**WEST SUSSEX COUNTY COUNCIL
STRATEGIC PLANNING CONSULTATION**

SUBJECT: LU/234/16/RES - Application for reserved matters relating to access, appearance, landscaping, layout and scale of the previously approved LU/63/11/. This application affects a Public Right of Way.

LOCATION: Fitzalan Link Road, Worthing Rd (A259), East Street, Littlehampton, West Sussex.

This is the fourth WSCC highways and transport response to the application seeking approval of reserved matters. Comments made below follow consideration of additional information provided in email from the applicant (Laura Graham of Persimmon Homes to Hilary Kernohan, Clare Potts and Tim Townsend) dated 30th November 2016. The text below should also be read alongside previous WSCC highways responses dated 21st September, 21st October and 21st November 2016.

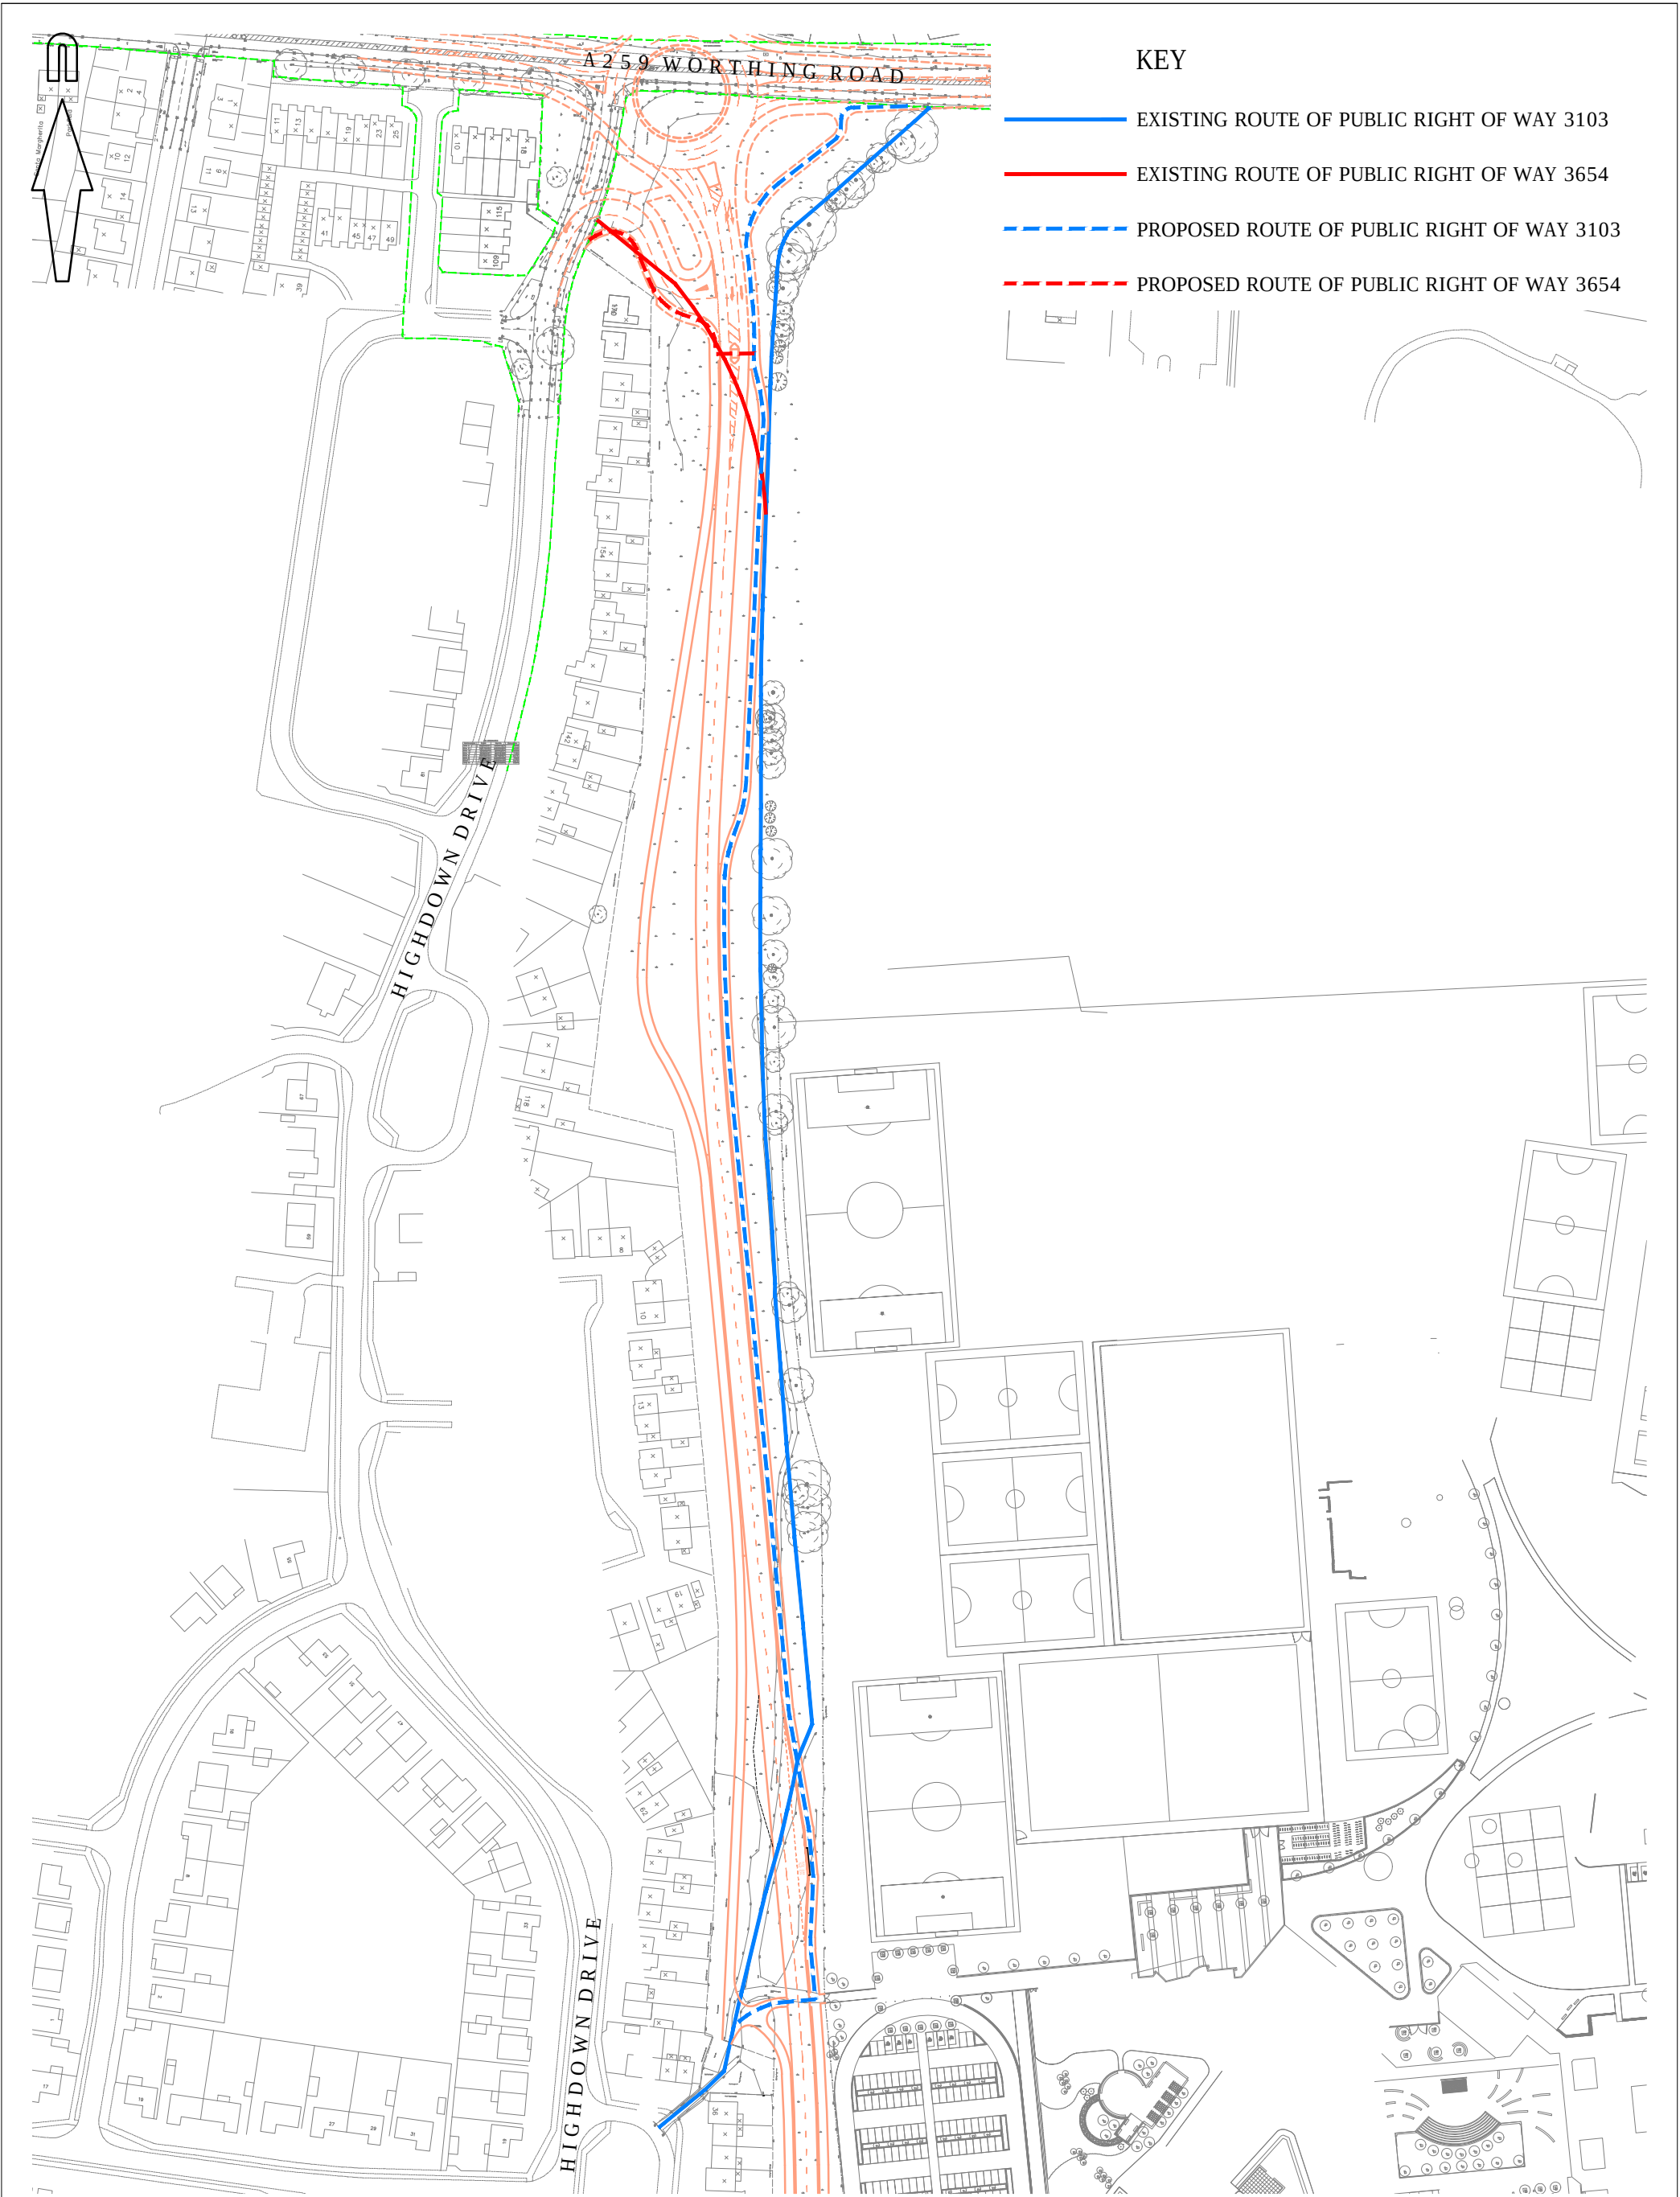
1. Red line boundary – This has implications for PRow connection in south-western corner (north of Academy roundabout) – please demonstrate that an appropriate design can be accommodated and correctly interact with existing PRow connection. As shown, the existing path and the new paths do not appear to tie-in. Also see 3 below. **Further information and alterations required.**

3. Shared footpath/cycleways alongside both sides of the access road – On the western side at the point the PRow joins the scheme, the alignment is very convoluted and may not meet appropriate design standards. Please amend and remove bends etc. This also applies to the 'kink' on the eastern side of the road found further north. Also, because of the increased speed limit along the majority of the road, it is recommended that the footpath/cycleways be set-back from the edge of the carriageway by a minimum of 1.5m wherever possible. Also because of the speed limit, a signal controlled crossing should be provided in this location (Toucan). Any design should be Safety Audited before planning consent is issued. **Please provide amendments, Road Safety Audit and Designer's Response.**

Accepted. The full extent of the land required to implement the outline consented scheme has not been made available. As a result, the alignment of the shared footway/cycleway has been altered from that indicated at Outline Consent stage. The geometry of the facility has been revised to provide a more suitable design and continuity of the PRow within the constraints of the site limits. The proposed PRow ties into the existing PRow route at the red line. Please refer to amended drawings PHF-MB-S278-GF-DR-D-210-01 Rev P5 and PHF-MB-S278-GF-DR-D-PROW-01 Rev P3.

Accepted. The full extent of the land required to implement the outline consented scheme has not been made available. As a result, the alignment of the shared footway/cycleway has been altered from that indicated at Outline Consent stage. The geometry of the facility on the western side has been revised to provide a more suitable design and continuity of the PROW within the constraints of the site limits. The proposed PROW ties into the existing PROW route at the red line. Please refer to amended drawings PHF-MB-S278-GF-DR-D-210-01 Rev P5 and PHF-MB-S278-GF-DR-D-PROW-01 Rev P3.
